Project: 7 Benfield Way, Portslade. BN41 2DA

Works: Amendment of dormer roof design to existing approved application 'Extensions to existing dormers with associated works'.

Ref: 2133-6.01-Cover Letter

2 SIDE ELEVATION - NORTH 1:100 PROPOSED

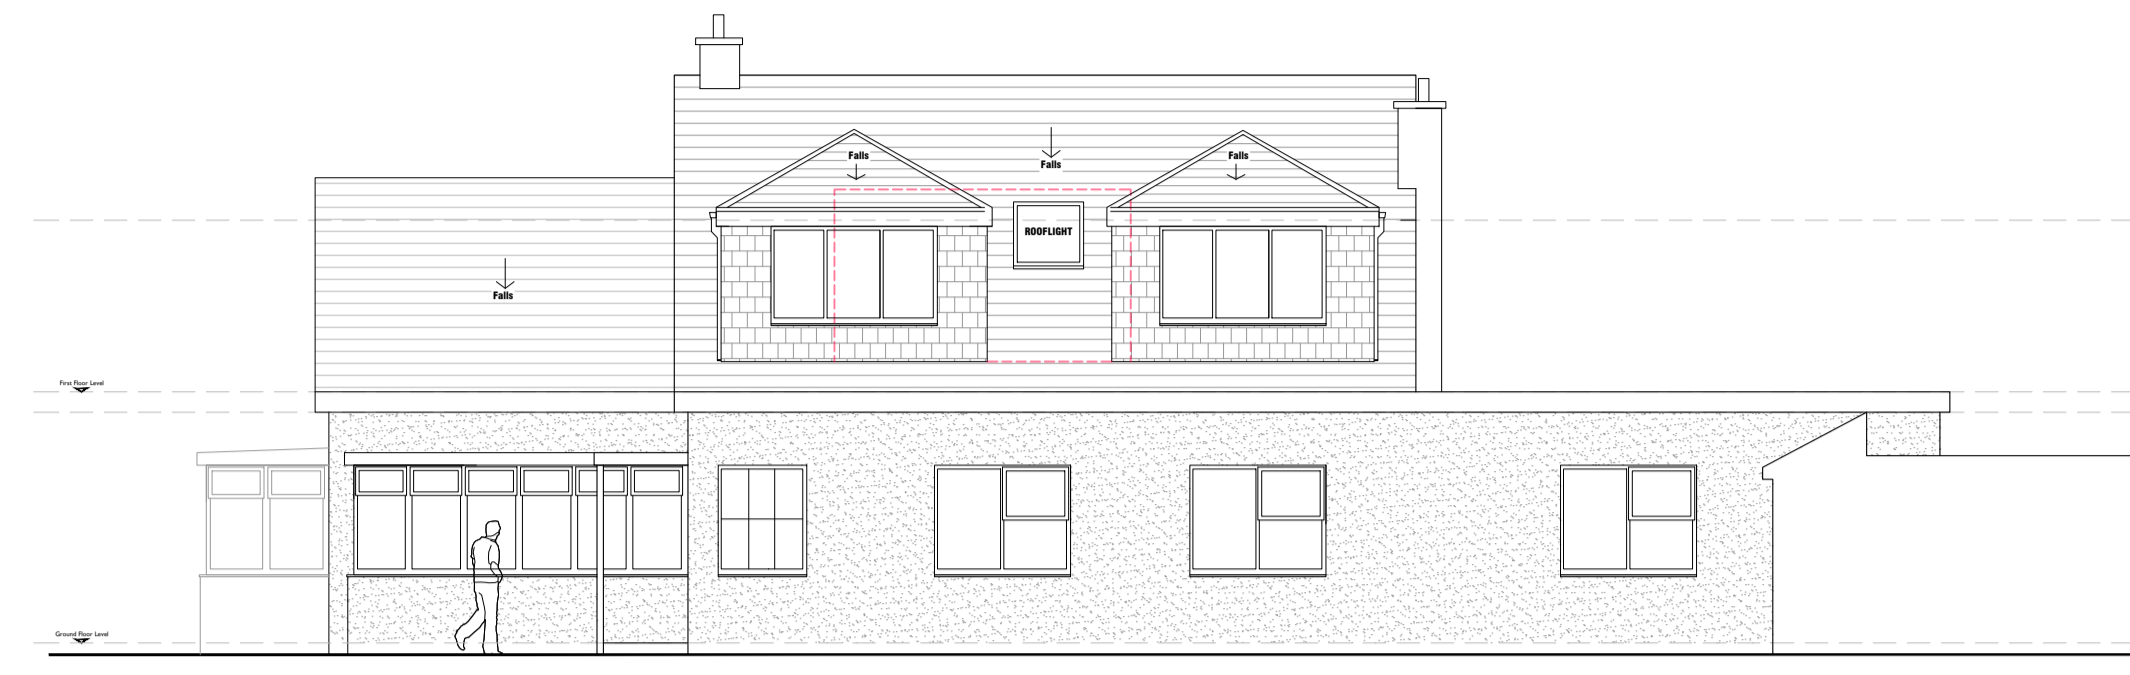
The applicants would like to propose a revised design for one of the dormers already approved. They would like to replace the flat roof of the larger north-facing dormer with a tiled pitched roof design which mirrors the approved dormer roof design on the opposite side of the house and also better reflects the main house and general context, of which most are tiled pitched roofs of varying aesthetics.
